PLANNING AND COMMUNITY DEVELOPMENT
CRAIG DOSSEY, EXECUTIVE DIRECTOR

December 21, 2017

Subject: VR-17-014 Review 1

AS PLATTED

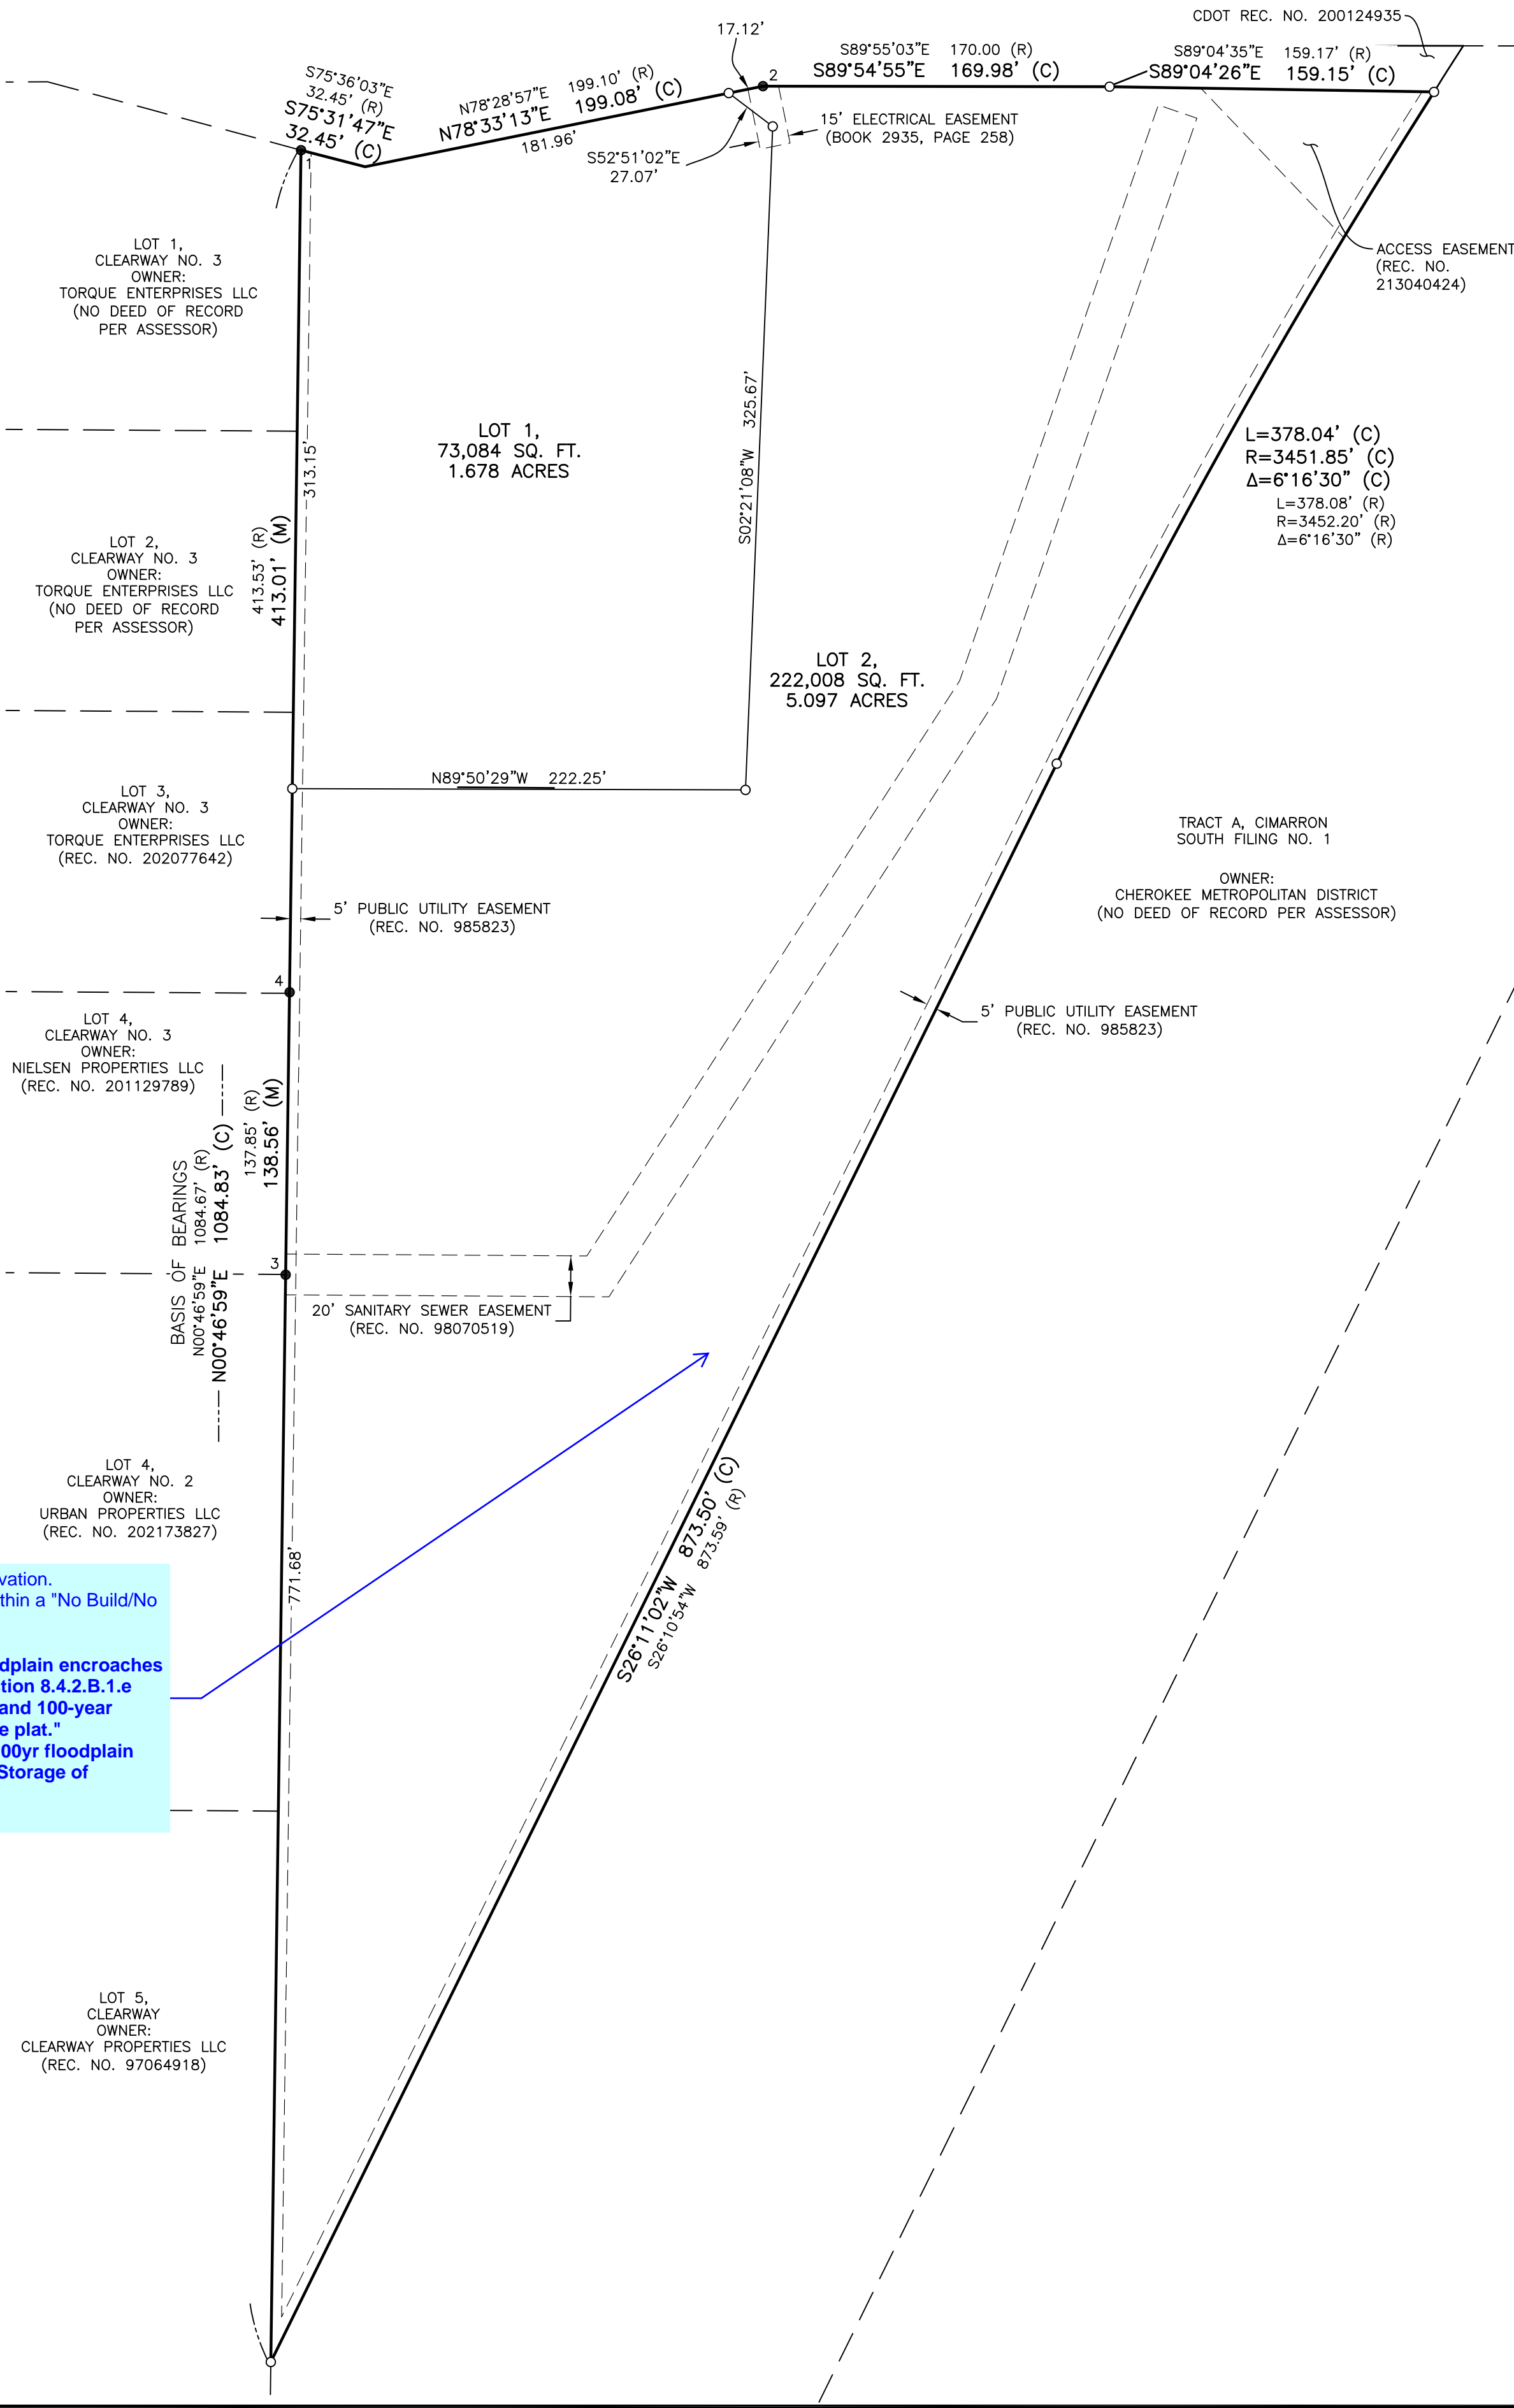
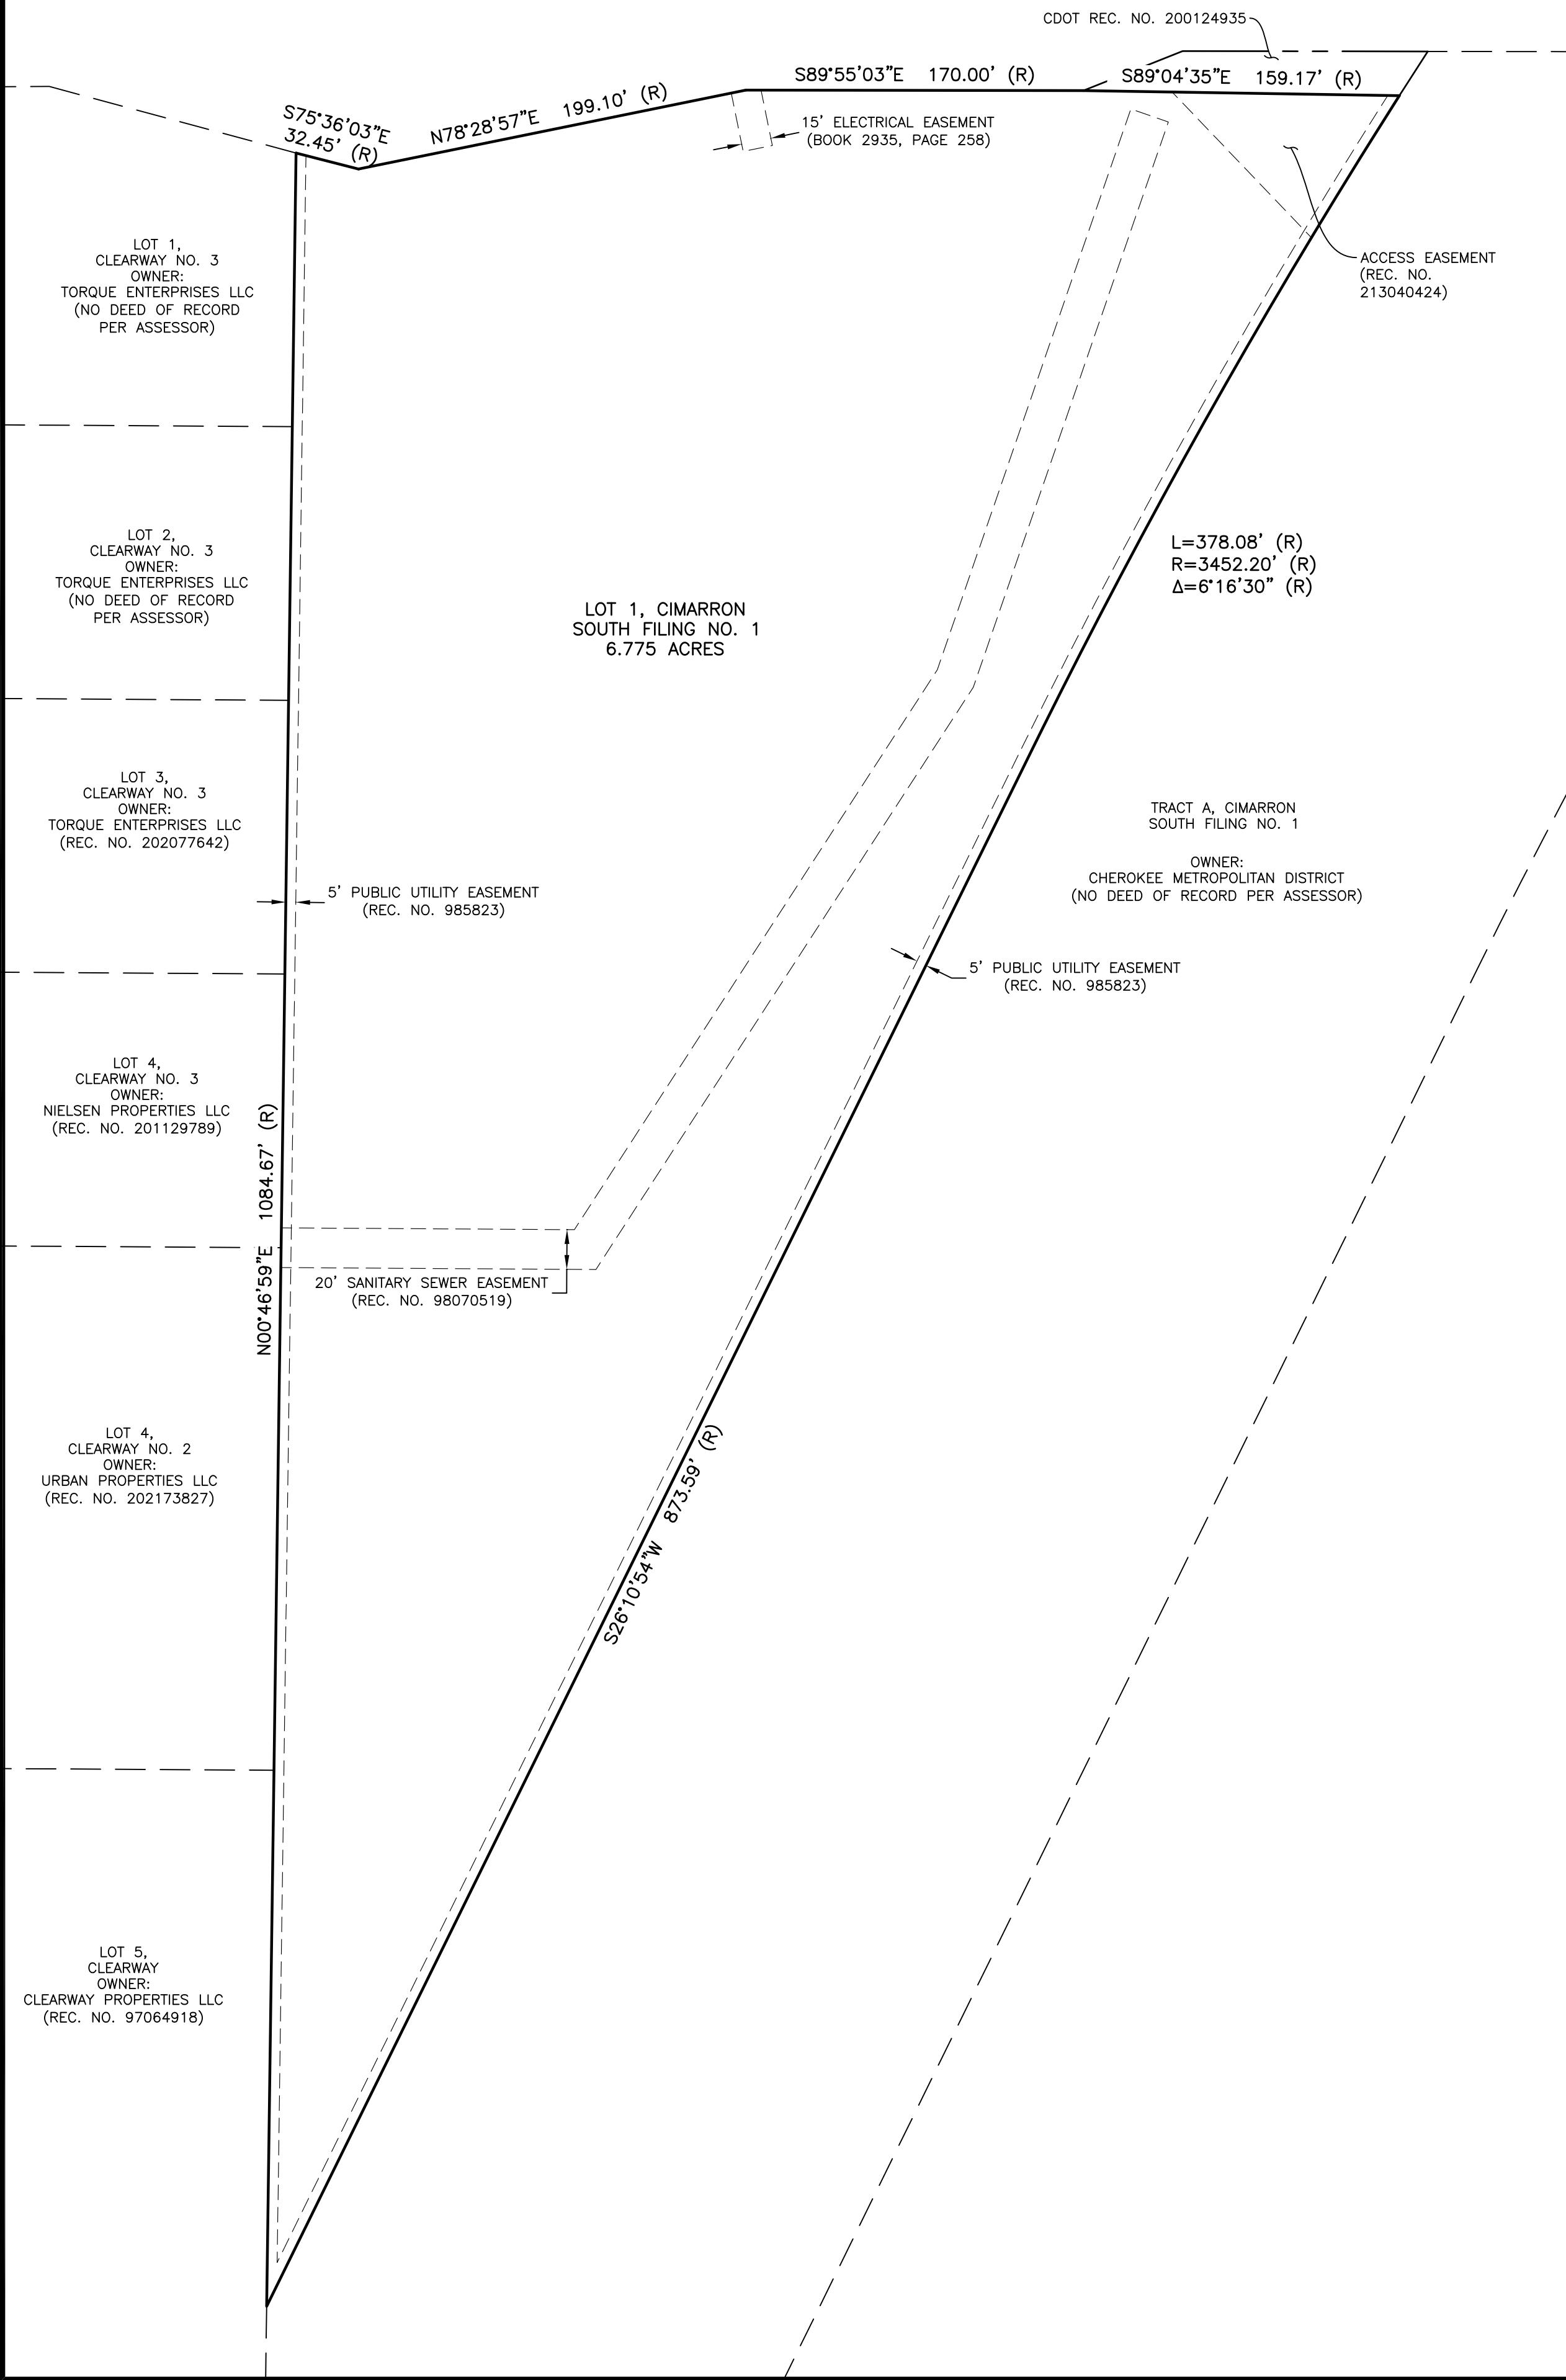
Per Clark Land Surveying: “The county is asking us to show the floodplain line, that they believe affects Lot 2 of the plat. It is our determination that the floodplain line does not affect Lot 2 and thus no changes were made in regards to that.” The revised plot plan and letter of explanation has been uploaded.
